FULL

Reference:	H05-0250-22	Date of Decision:	29th April 2022
Applicant:	Mr J Sidebottom 2 Greenfields Holbeach Spalding PE12 7BJ		
Location:	2 Greenfields Holbeach Spalding		
Description:	Proposed front extension, detached single garage and connecting carport

PROPOSED FRONT ELEVATION

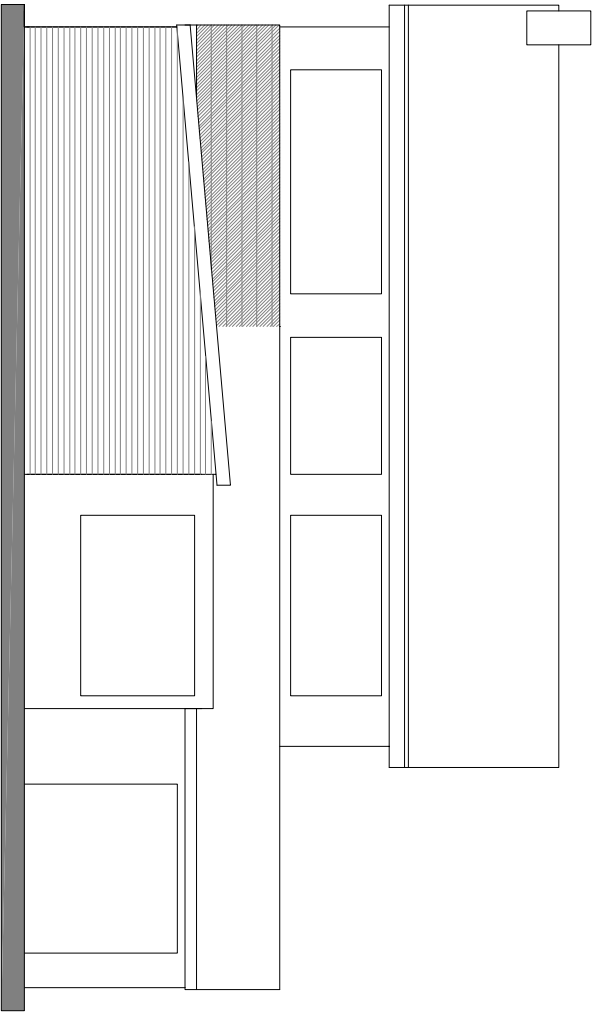
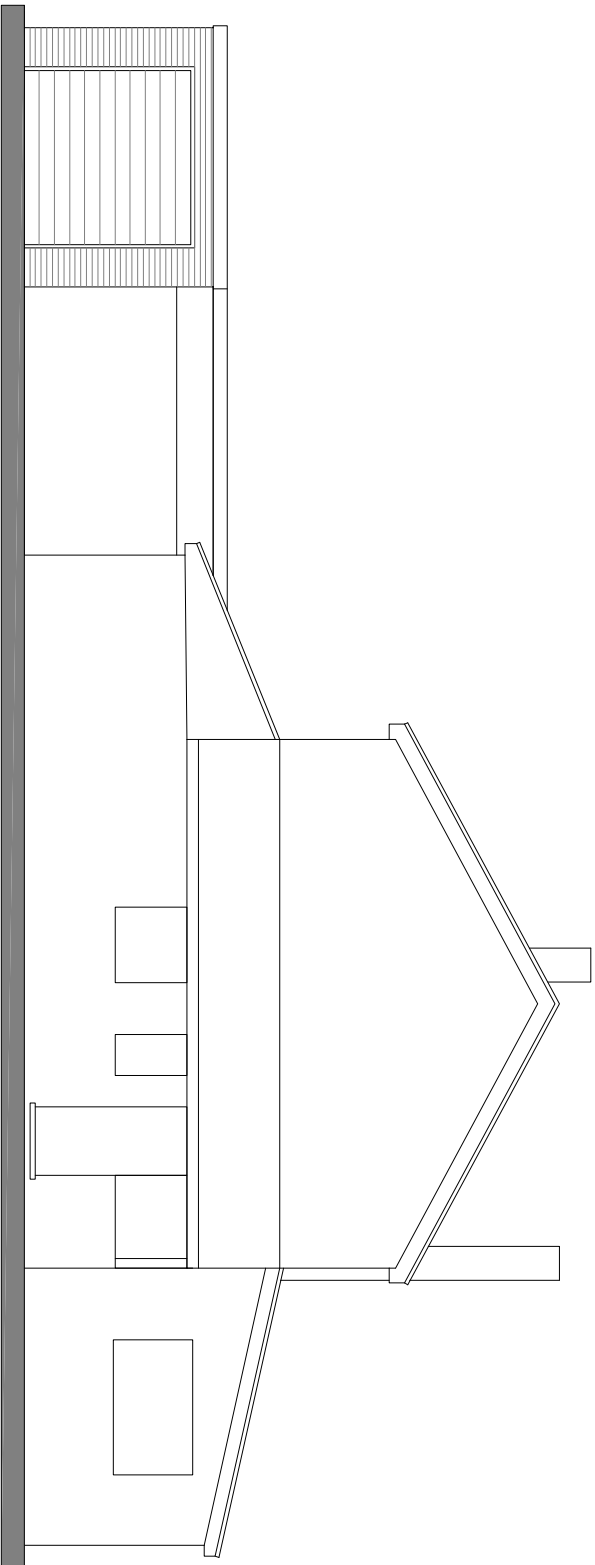
- 1 The site is inside the Holbeach Settlement Limit as defined in the South East Lincolnshire Local Plan (SELLP), 2019. However, the proposal would appear overly prominent and visually intrusive in the street scene to the detriment of the character and appearance of the immediate area.
